From: Andrew Wood <Andrew.Wood@arun.gov.uk>
Sent: 14 August 2020 14:29
To: Planning.Responses <Planning.Responses@arun.gov.uk>
Subject: FW: AB/49/20/L

Sent: 07 August 2020 17:04
To: Juan Baeza <Juan.Baeza@arun.gov.uk>
Cc: Andrew Wood <Andrew.Wood@arun.gov.uk>; Martyn White <Martyn.White@arun.gov.uk>
Subject: AB/49/20/L

Proposed Ground Floor Plan
(Showing structure over)
(1:50)

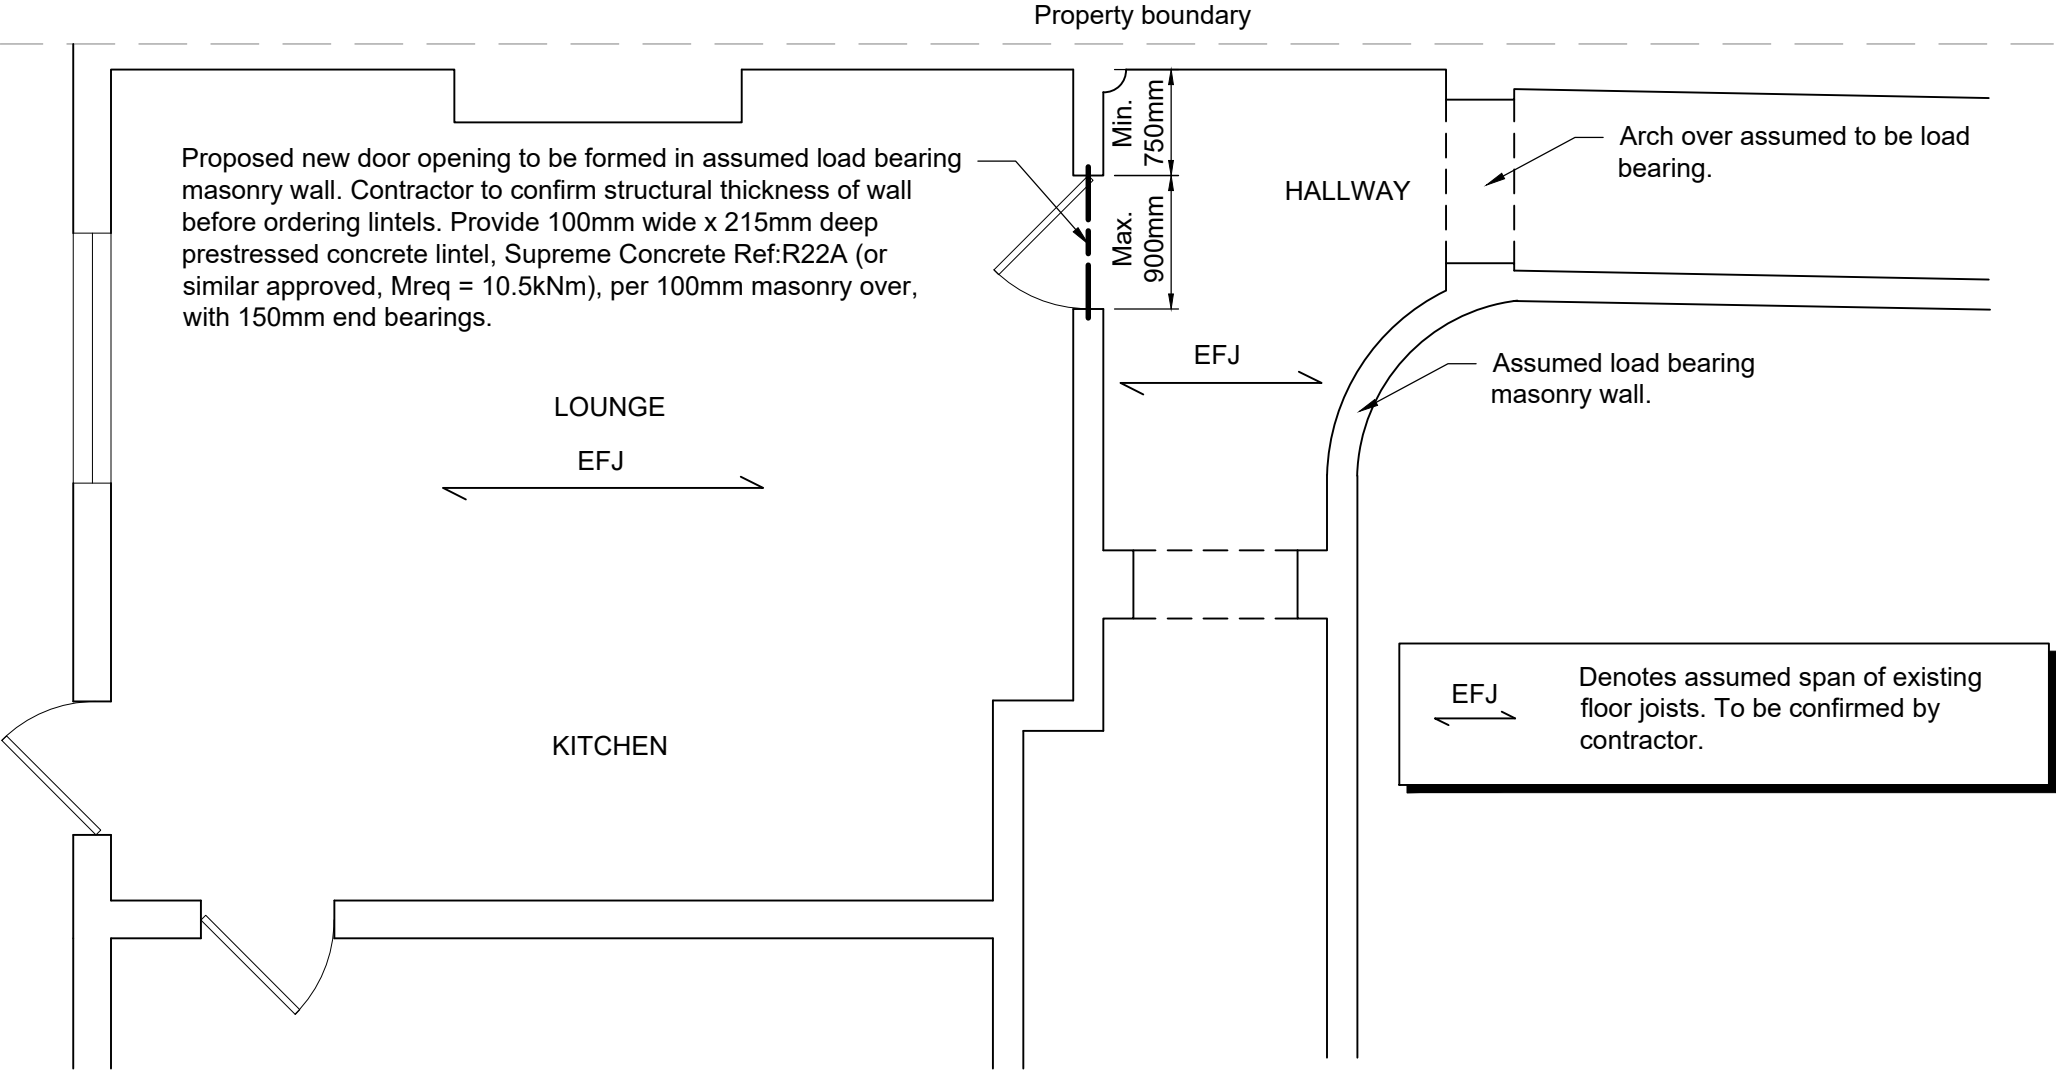
I also note that his concerns about the undeclared entrance and the removal of historic fabric have not been alleviated. Further, I have pointed out clearly in my objection that a fundamental assumption of Philip Goacher's structural engineers report is incorrect, yet no clarification has been sought in that regard?

Proposed Ground Floor Elevation (1:50)

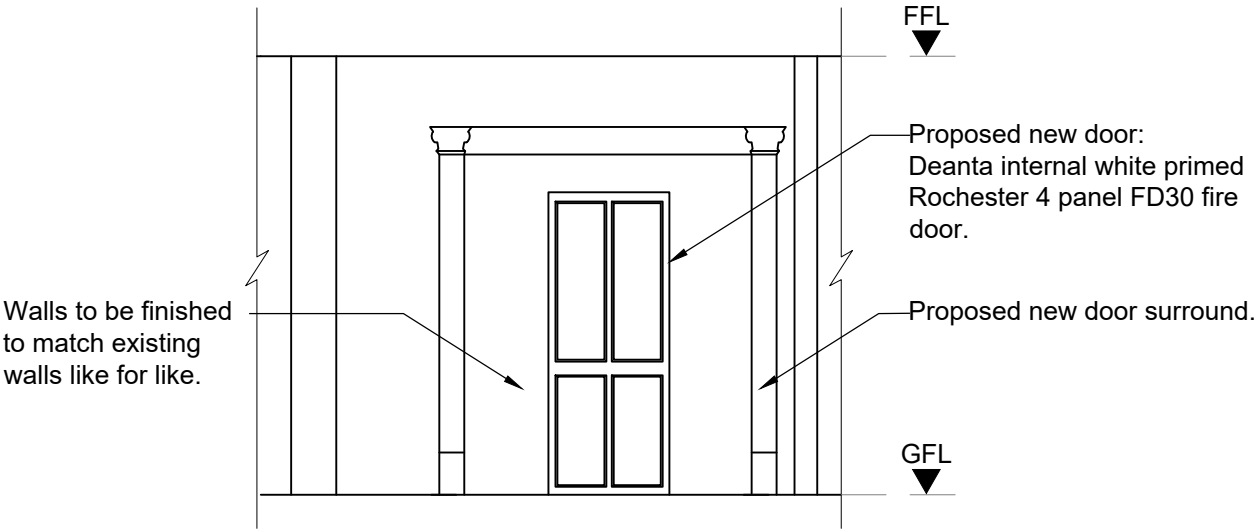
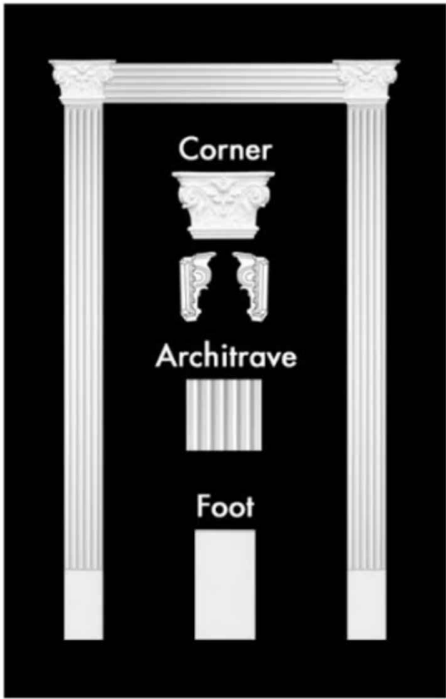
I have just spoken with Martyn White. I am concerned, new plans and designs have been submitted as part of this application but have not been posted within the consultation period, they were only passed to Martyn White for comment whereas for example he was unaware that the proposed door would be completely different to the existing doors within the communal areas of 57a.
